**WELWYN HATFIELD BOROUGH COUNCIL
ASSISTANT DIRECTOR (PLANNING)**

DELEGATED APPLICATION

Application No: 6/2024/0120/HOUSE
Location: 21 Theobalds Road Cuffley Potters Bar EN6 4HQ
Proposal: Proposed loft conversion including two side dormers, a roof light window and insertion of a first floor window to the front and rear elevations
Officer: Mrs Kerrie Charles

6/2024/0120/HOUSE

Proposed East Elevation

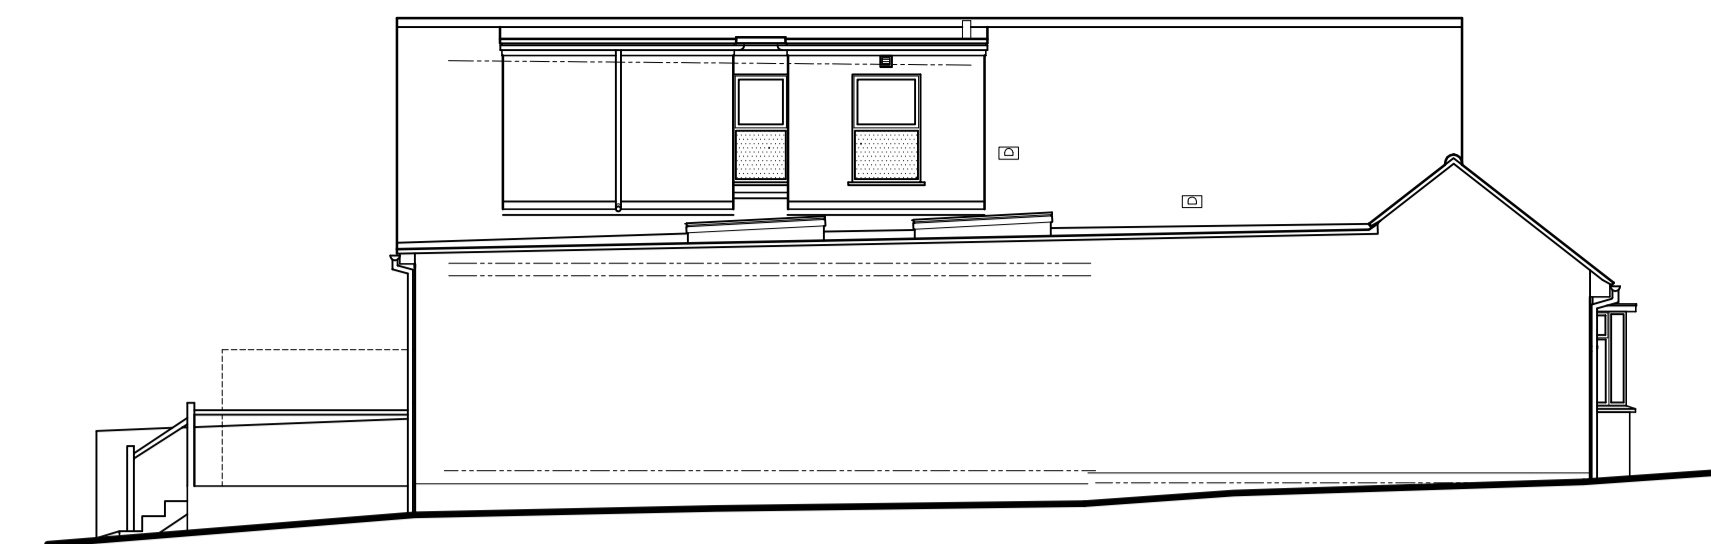
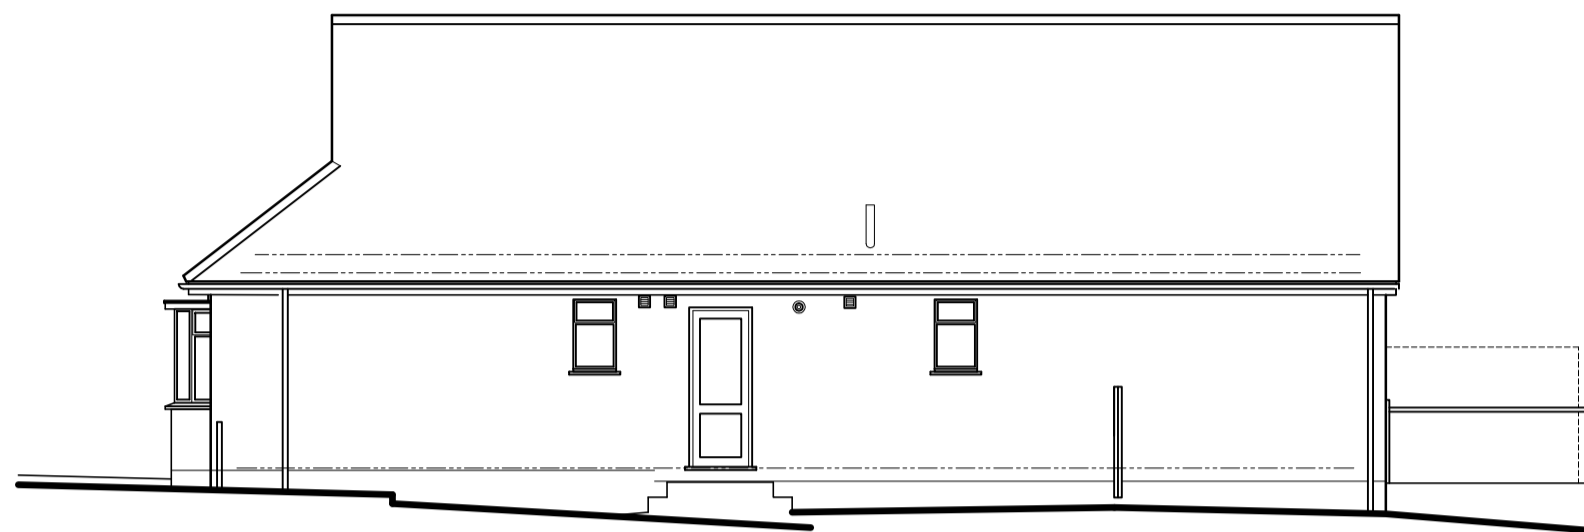
Comment (if applicable):			
Would the development reflect the character of the area?			
<input type="checkbox"/> Yes <input type="checkbox"/> No			
Comment (if applicable): Theobalds Road and surrounding roads such as Northaw Road East predominantly consist of single storey bungalows of a similar style to the application dwelling, with simple hipped roofs. Over time, a number of these properties have been extended and the loft space converted to create habitable accommodation at first floor level. There are several similar examples of this form of development on Theobalds Road, namely adjacent no 19 (to the north) and no 23 (to the south).			
The application property is currently single storey and benefits from a garage to the side. At the time of the officer site visit, construction works were underway to build out planning consent ref: 6/2023/0620/HOUSE.			
This planning application seeks planning permission for a proposed loft conversion including two side dormers, a roof light window and insertion of a first floor window to the front and rear elevation to facilitate additional living accommodation at roof level. The dormers would be identical in scale,

size, form and height and position, symmetrically aligned within the roof and set back towards the rear end of the building, which to a degree reduces its visual prominence from the public realm. The dormers would allow sufficient spacing from the main roof's ridge, eaves and cheeks, therefore, provide some visual relief and thus appear visually contained and subservient within the roof form. The new openings in the front, rear and side roof slopes would support new rooms within the loft space and would be considered acceptably sized and positioned.

Plans show window openings be set within the walls of the proposed dormers. As adjacent no's 19 (to the north) and no 23 (to the south) have carried out similar works, there is a potential for direct overlooking into neighbouring bedrooms. Therefore, to mitigate the potential for actual/perceived overlooking, a condition has been imposed to ensure that new openings are obscurely glazed and non-opening 1.7 metres above the floor of the room in which the window is installed.

3. Any upper floor window located in a roof slope forming a side elevation of the building must be obscure-glazed to a level equivalent to Pilkington Level 3 or above and non-opening unless the parts of the window which can be opened are more than 1.7 metres above the floor of the room in which the window is installed, and shall be retained in that form thereafter. Obscure glazing does not include applied film or one-way glass.
